From: Bruce Taunton
Sent: 15 January 2018 14:35
To: Planning.Responses
Subject: RE: Planning Consultation on: CM/34/17/L

Listed Building Consent for Alterations, Extension or Demolition of a Listed Building
APPLICATION CM/34/17/L
NO:

Registered: 8th January
2018
Site Address: Clymping Mill Clymping Street Clymping BN17 5RN
Grid Reference: 501571 101201

SECTION - NORMAL CONDITIONS

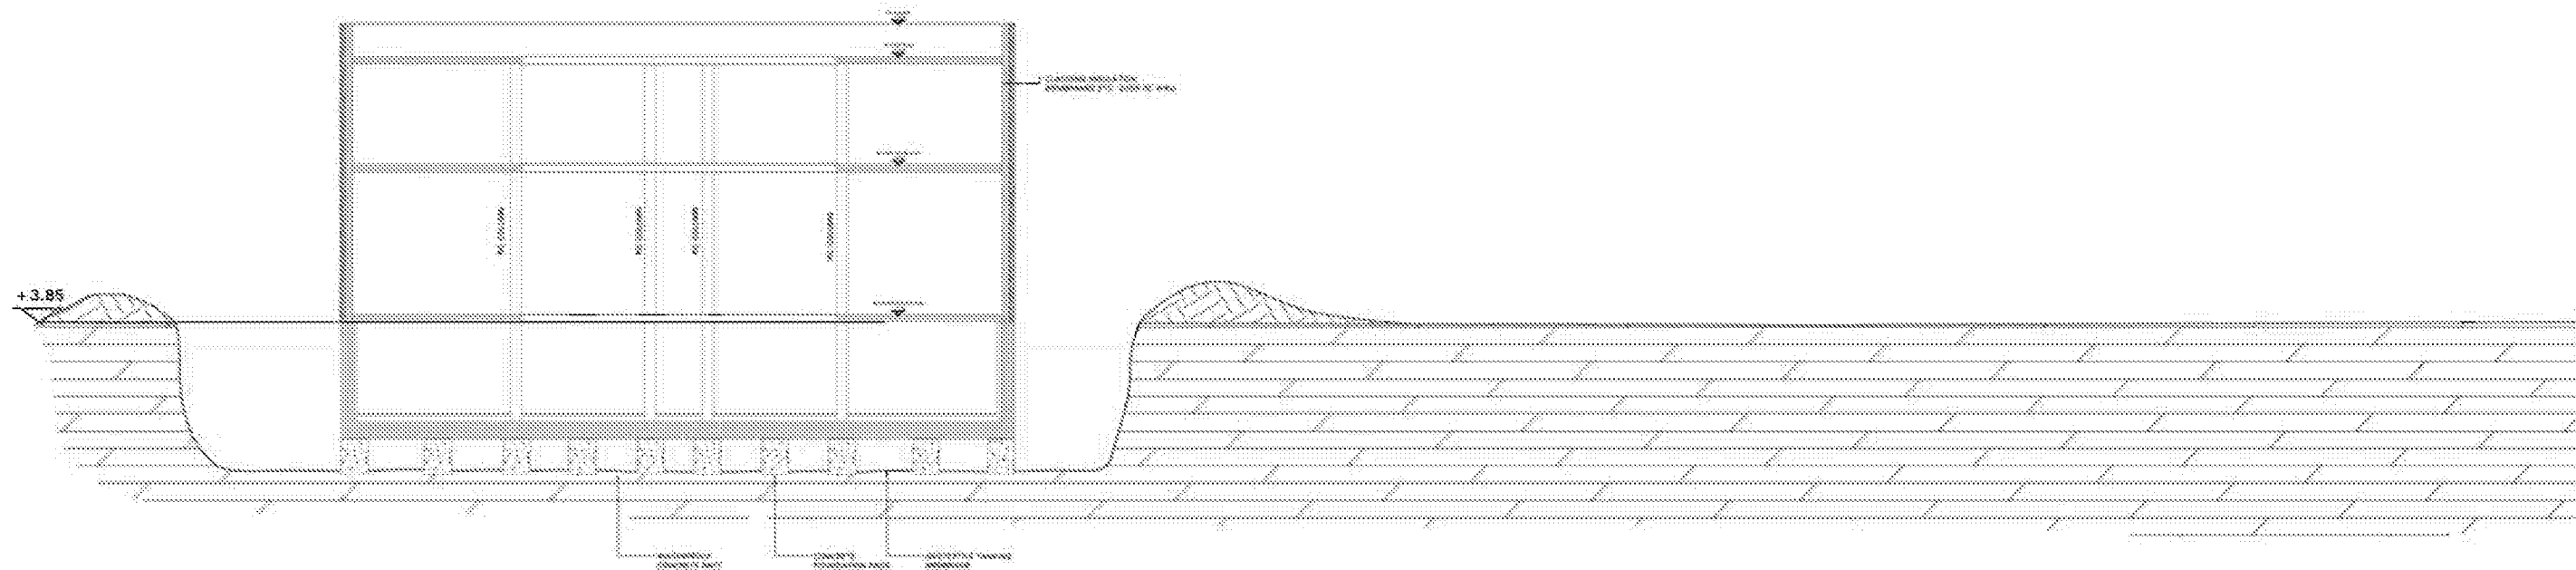
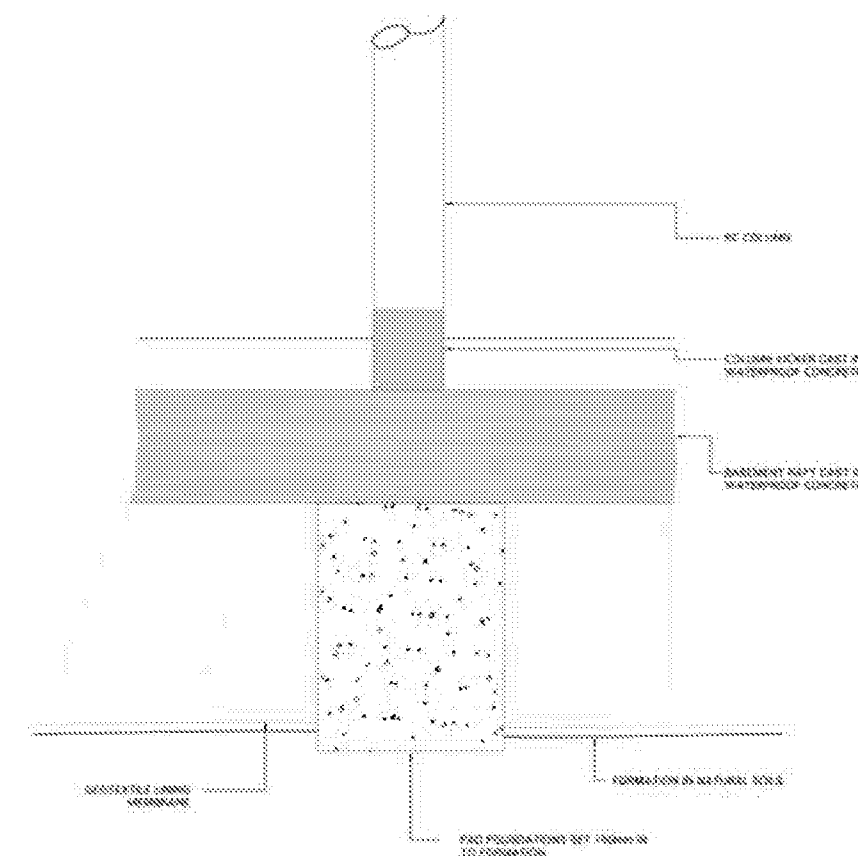
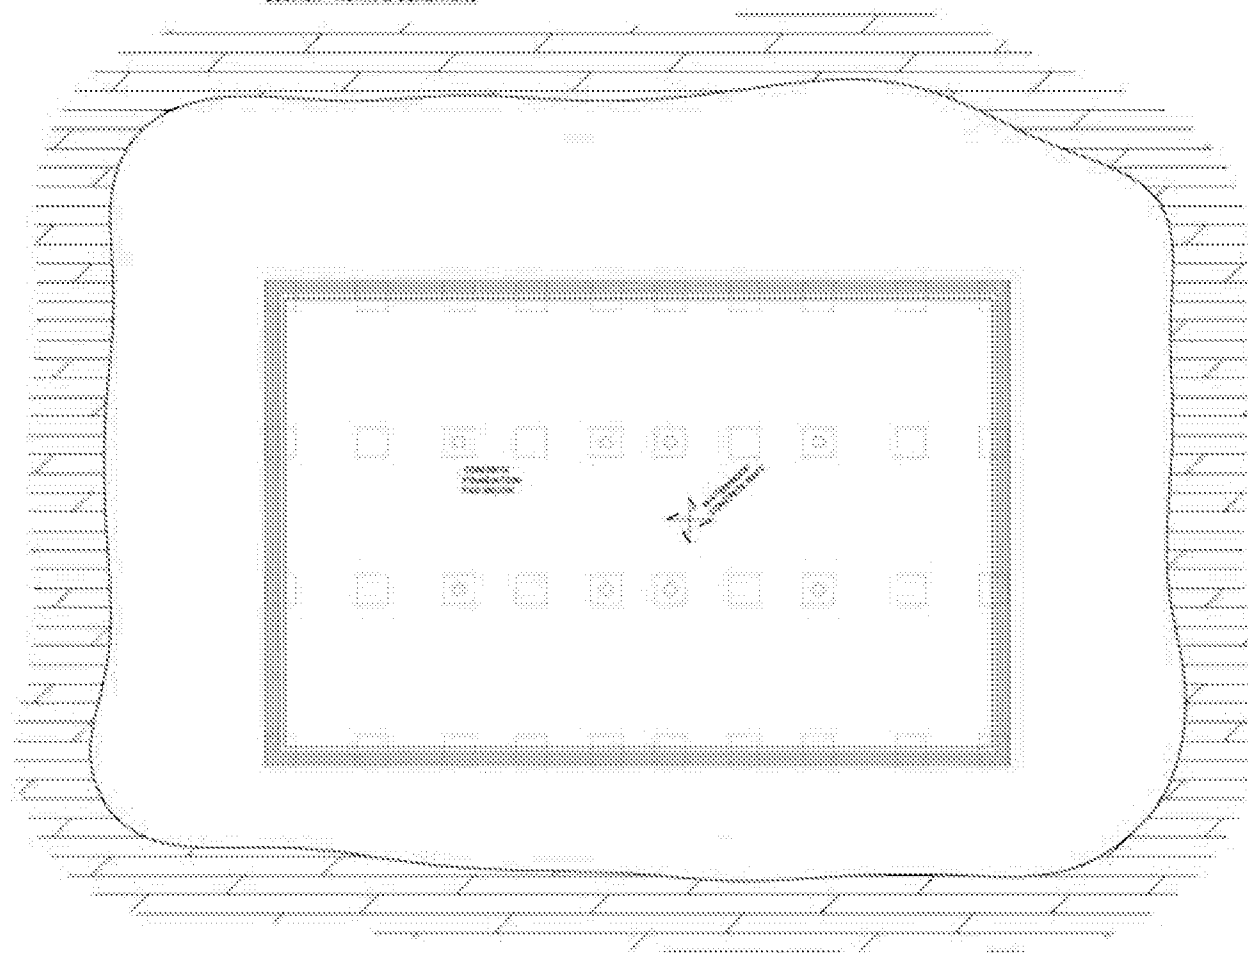
With respect to the floating house the majority of elements will be covered under the Building Regulations however considering the mass of the new building is it actually capable of floatation. In addition how are essential services such as water and foul drains kept operational should the building be capable of achieving buoyancy. If the building does achieve buoyancy there did not appear to be any indication of how the building was to be kept in position and stop it floating off of its pad base supports.
